12 February 2020

**DPIE request for Advice - Glendell Continued Operations Project - SSD 9349**

I refer to your request via the NSW Major Projects Planning Portal for advice from Singleton Council on the Environmental Impact Statement for the Glendell Continued Operations Project (**SSD9349**), as follows:

Figure 7: Proposed MIA and Conceptual Hebden Road Realignment (Northern Section)

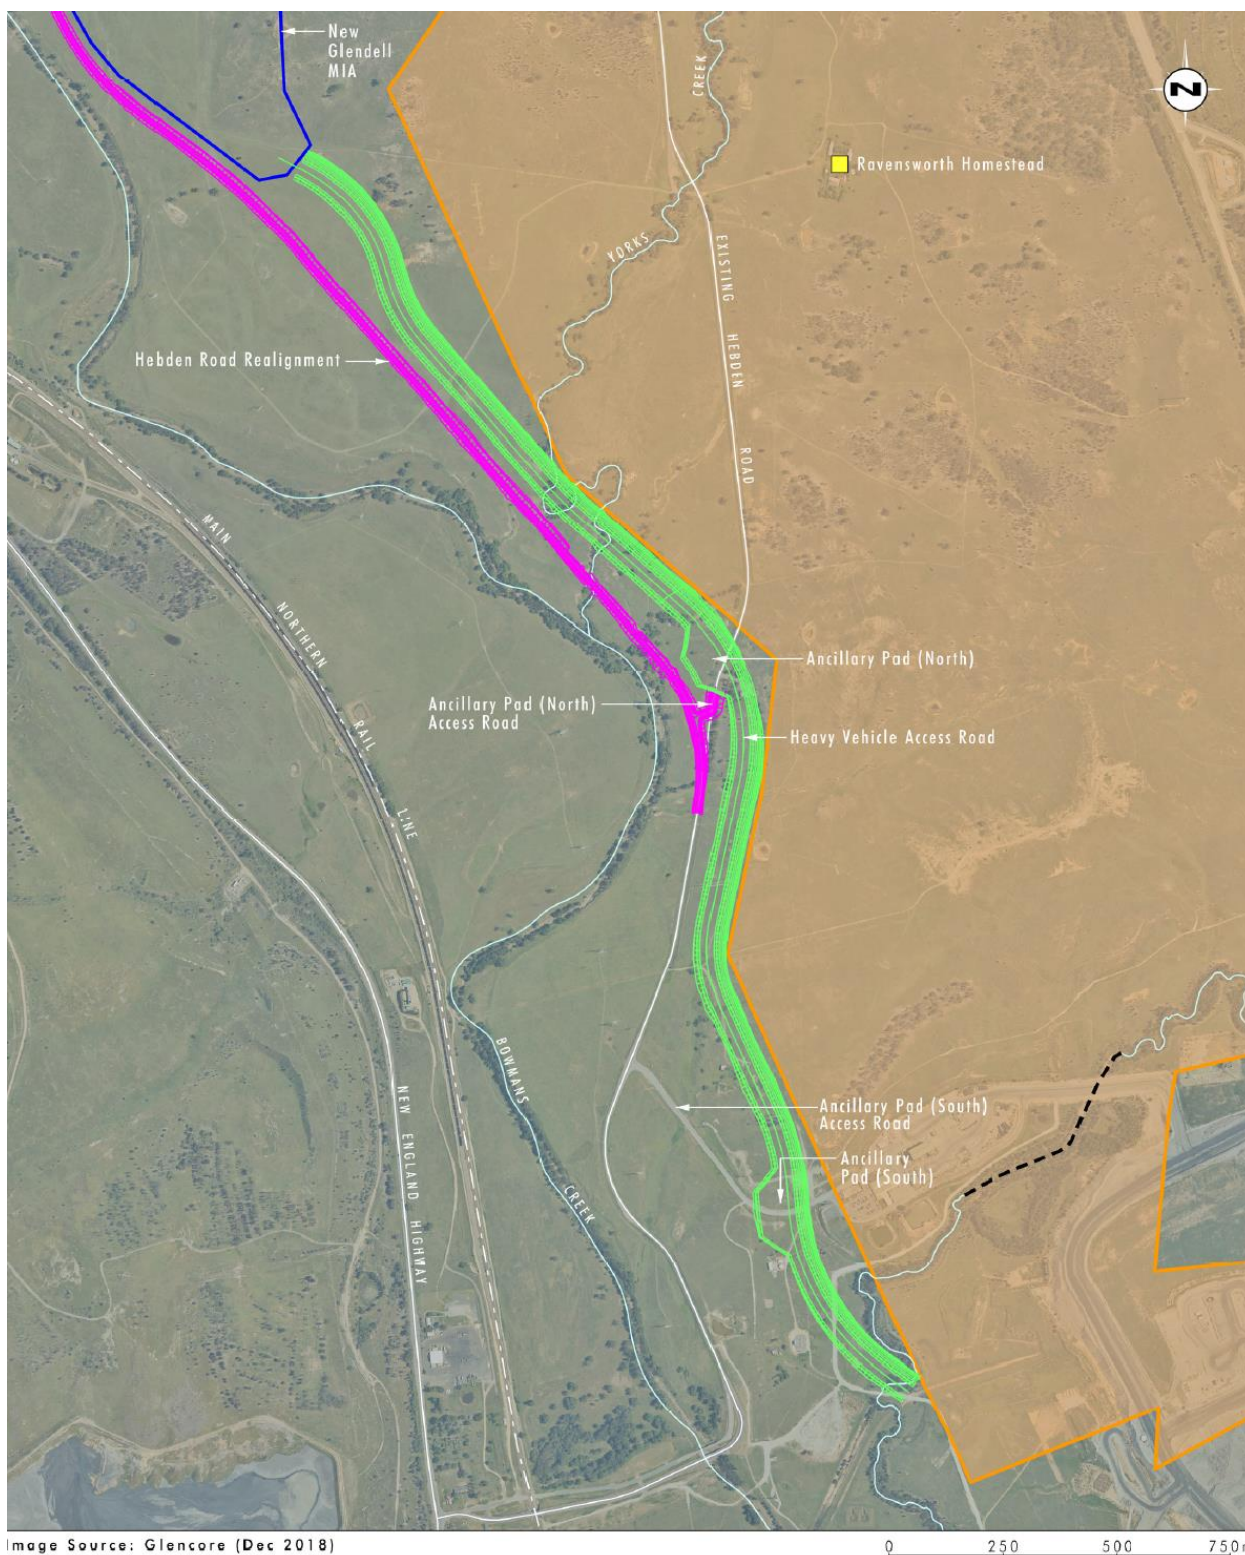
The EIS has determined that the only option in order for the Project to proceed is the realignment of Hebden Road. Council, in its submission to the SEARs, requested that the EIS undertake an assessment of all options, including the no relocation option. The EIS does not include an assessment of the consequences of not relocating Hebden Road.

The proposed realignment of Hebden Road will result in a significant increase in annual travel time, the equivalent of 80 days<sup>1</sup> additional travel time per annum across all road users. In addition, the Project proposes blasting delays of up to 15 minutes per vehicle per blast, resulting in lost time of 4.5 days per year for road users. The costs associated with these delays are estimated to be \$6.07M<sup>2</sup>. The impact to road users, including local bus and school bus services and other commercial users, is therefore significant.

The Environmental Impact Statement for the Project does not consider how the old Hebden Road closure would be undertaken as per the requirements of the *Roads Act 1993*. The EIS does not include the requirement for the Applicant to enter into an agreement with council for treatment of both the new and old Hebden Roads.

1. How the Applicant intends to provision for the long term (in perpetuity) maintenance of the new Hebden Road to meet the asset life requirements;
2. How the Applicant intends to progress the closure of the old Hebden Road alignment, having regard to the provisions of the *Roads Act 1993*; and
3. The impact of not realigning Hebden Road, including transparent costs and lost coal value, and the consequent environmental, social and economic impacts and benefits of not relocating the road.
